Recommendation Report for Planning Permission

**REF NO:** FG/15/25/PL

**LOCATION:** Kivesborough  
Littlehampton Road  
Ferring  
BN12 6PN

**PROPOSAL:** Subdivision of existing curtilage and erection of 3 No. 3-bedroom dwellings (self build), retention of existing access and provision of landscaping (resubmission following FG/49/24/PL). This application affects a Public Right of Way and is in CIL Zone 4.

Plot 2-3 Ground Floor Plan
 1 : 100

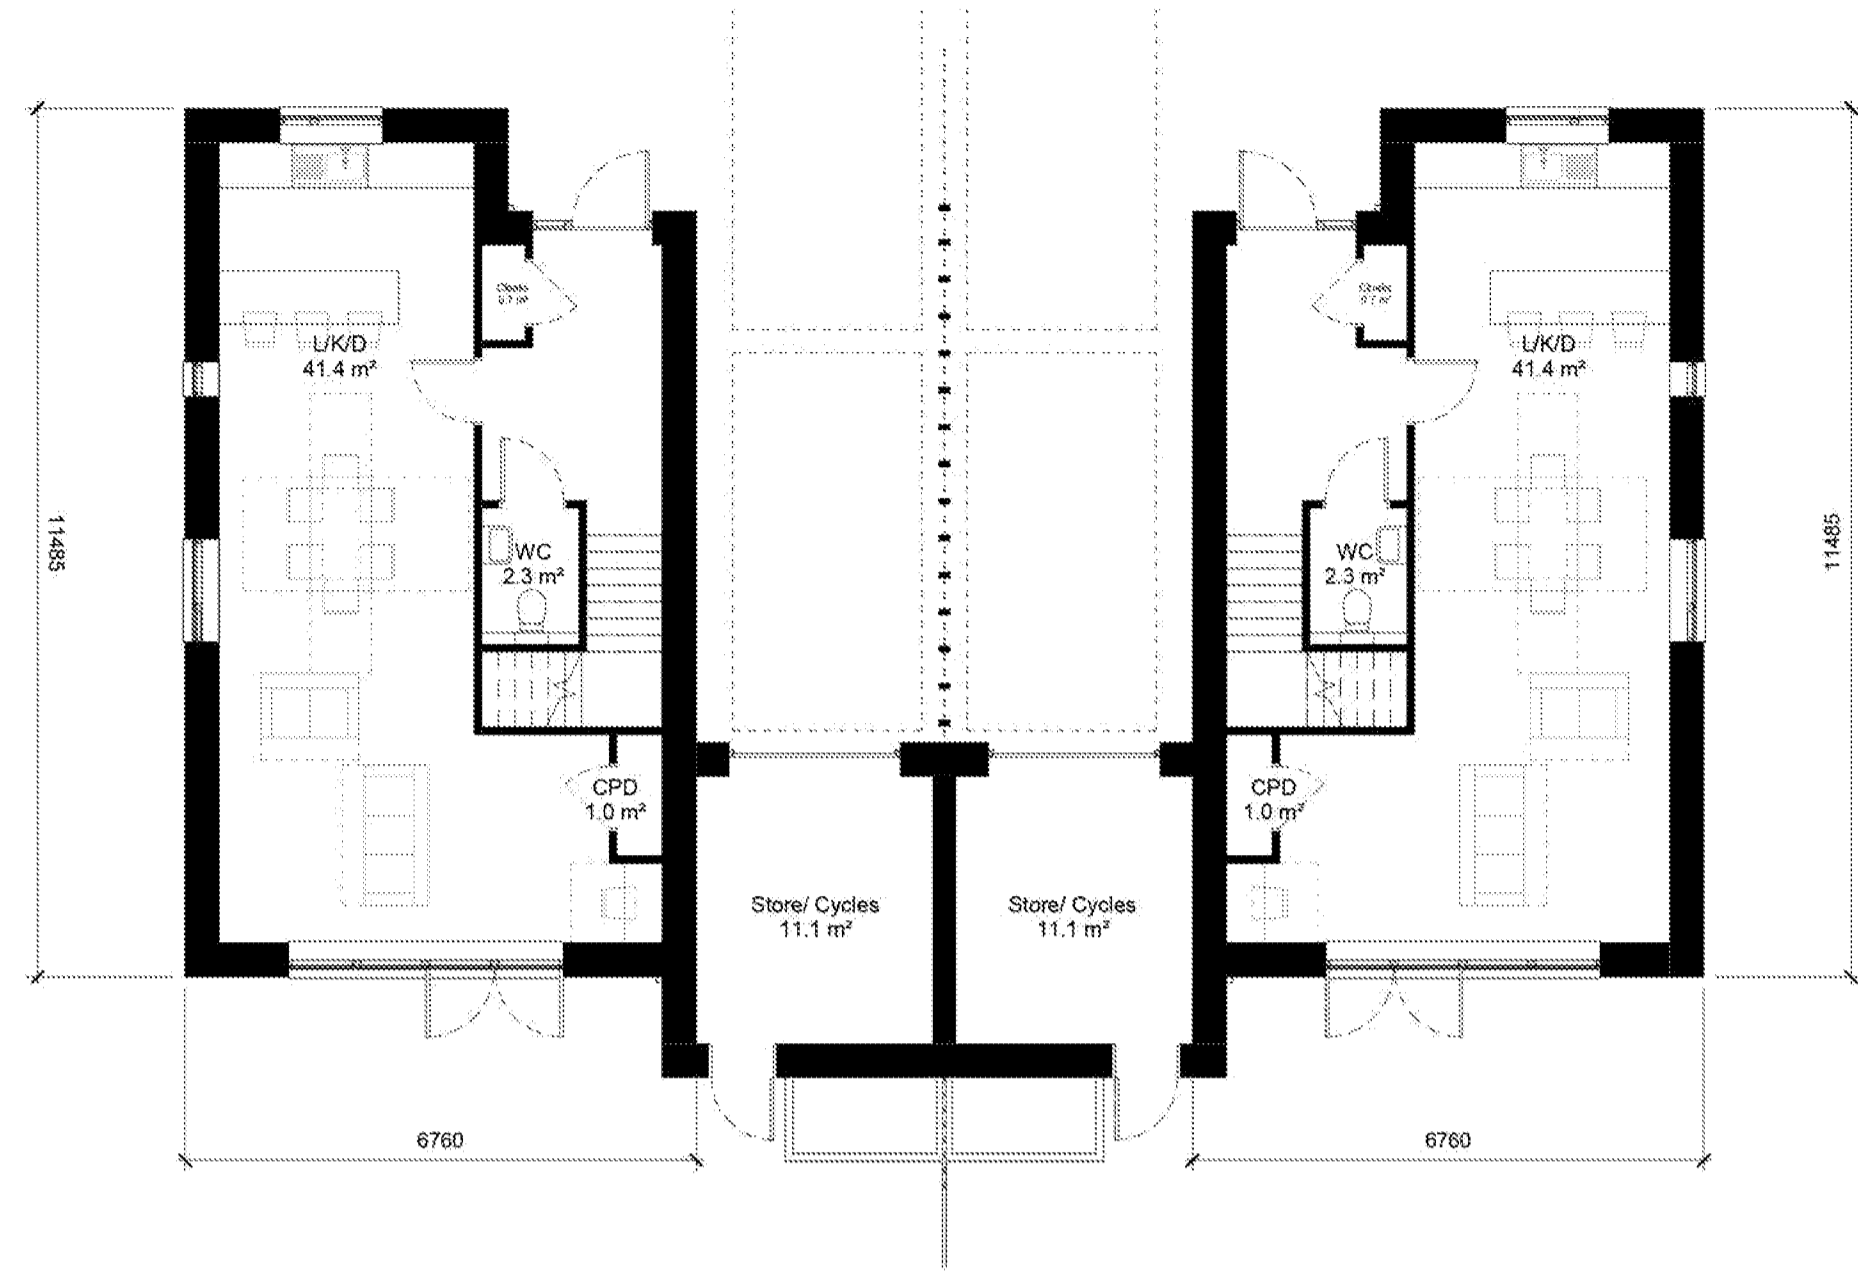
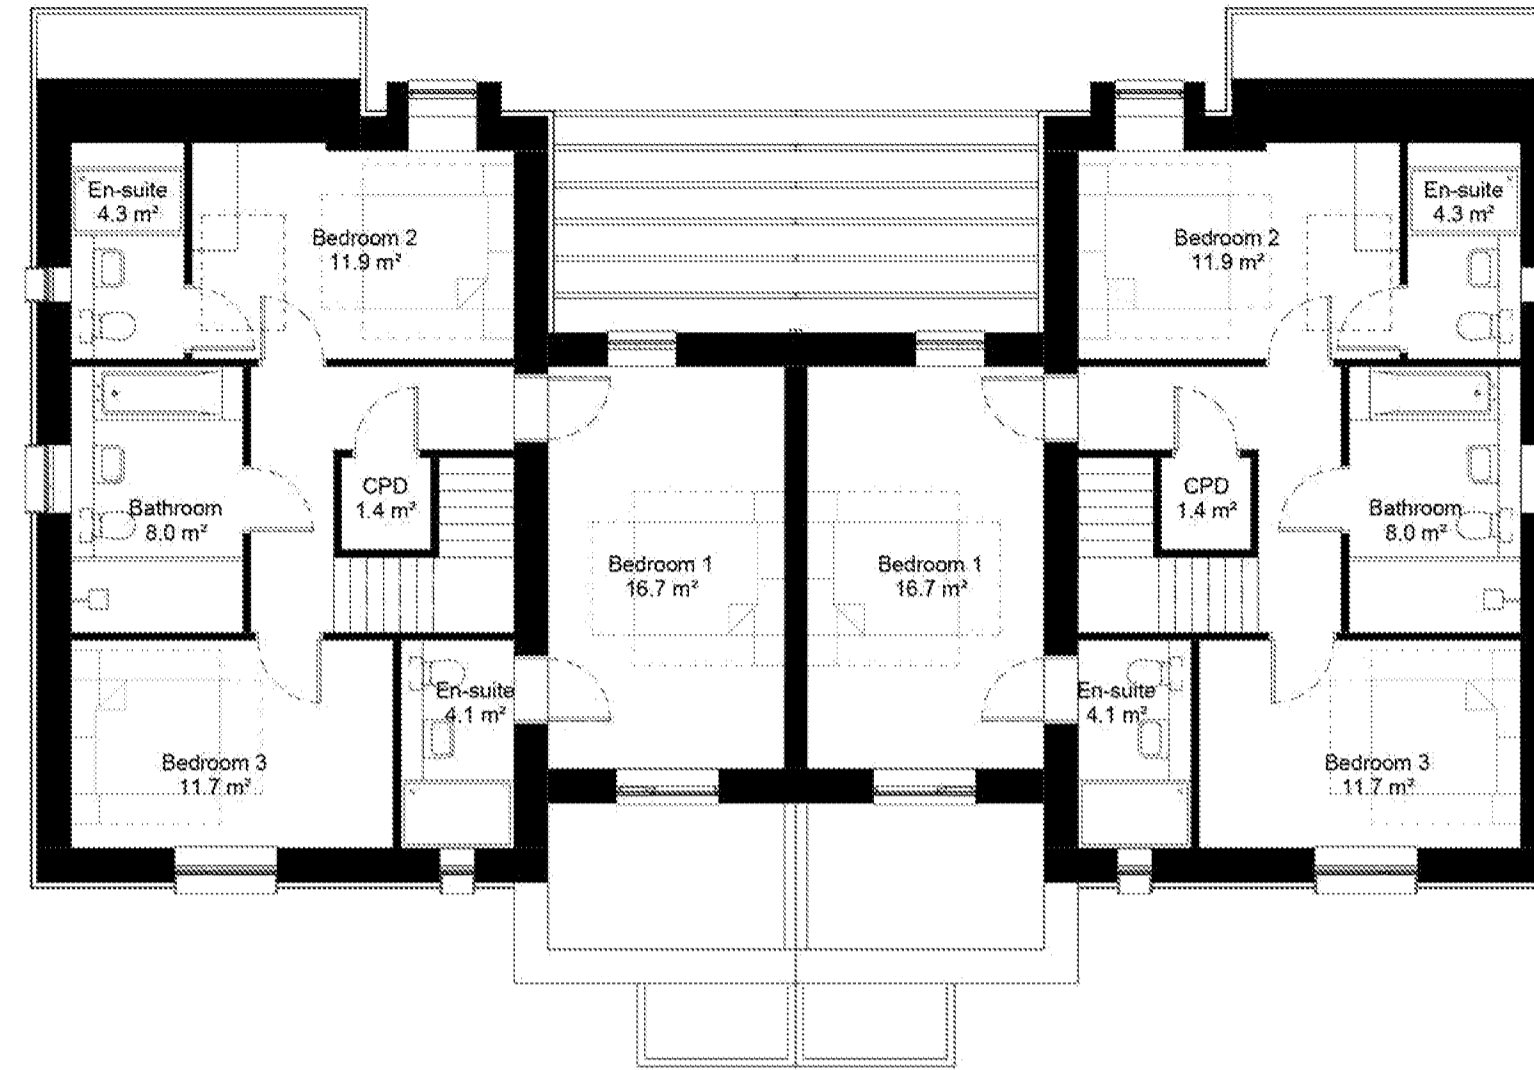
In terms of overlooking, the windows to the east elevation of Plot 3 are either at ground floor level or would serve bathrooms/en-suites. Those serving the bathroom and en-suite would be obscure glazed and would have been conditioned as such, and those to the ground floor would be met by boundary fencing and planting. The proposal would not result in any unacceptable overlooking impacts of Kivesborough. As part of the submitted acoustics assessment, an acoustic fence at 2m in height is proposed to the north, west, and south site boundaries. This would afford the forward amenity space of Lynton with sufficient privacy from the rear ground floor openings of Plots 2 & 3.
